23 October 2013

**Re: Additional Information Responding to Submissions to a State  
Significant Development Proposal for a Glass Beneficiation Plant  
(SSD 5267)**

**Property: No. 126 Andrews Road, Penrith**

LANDSCAPE CONSTRUCTION PLAN -VEGETATION MANAGEMENT PLAN

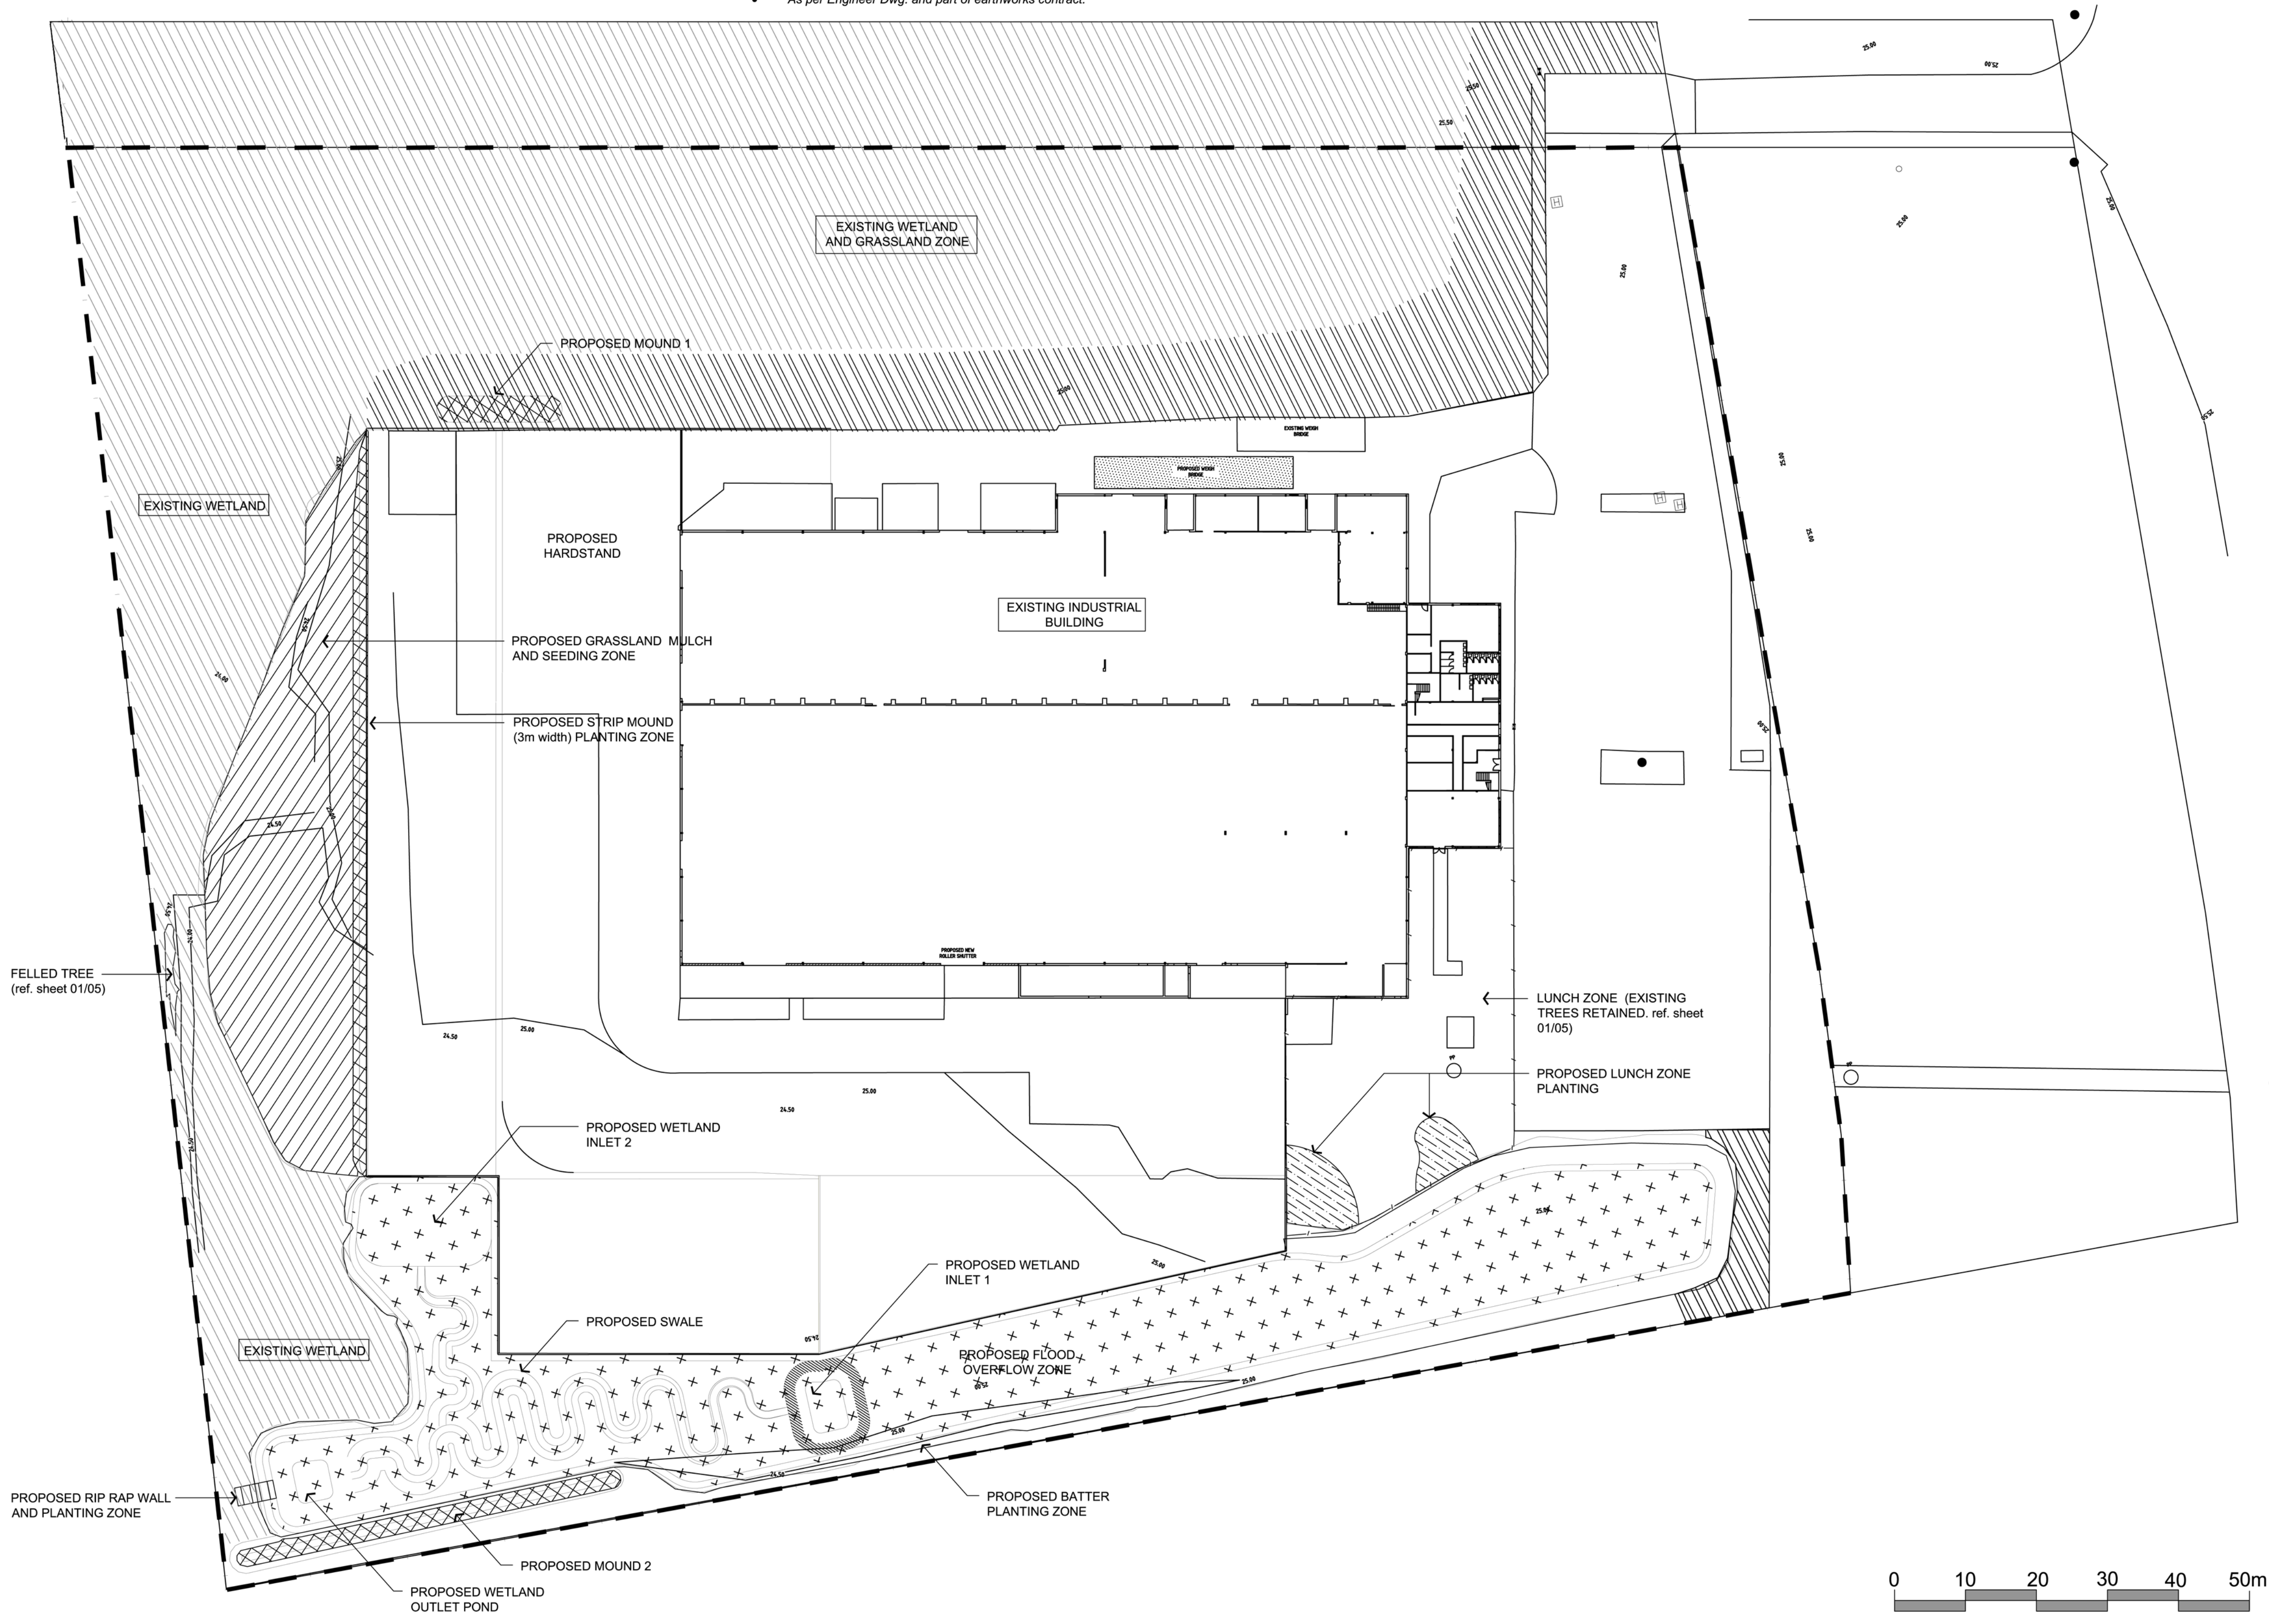
The "Amended Landscape Construction Plan for SSD 5267 Penrith Glass Beneficiation Plant" (prepared by Bio-Design, 12/9/2013) provided to Council only contains Drawing 3/5 (Landscaping Construction Plan – Vegetation Management Plan). The other drawings in the series are not provided and have not been provided previously. To enable adequate review of the additional information, all drawings associated with the "Landscaping Construction Plan – Vegetation Management Plan" (prepared by Bio-Design, 12/9/2013) need to be provided.

It is also unclear if the "Landscaping Construction Plan – Vegetation Management Plan" replaces Figure 5-45: Landscape Concept Plan in the original Environmental Impact Statement. The Department is requested to clarify if the "Landscaping Construction Plan – Vegetation Management Plan" replaces Figure 5-45: Landscape Concept Plan in the original Environmental Impact Statement.
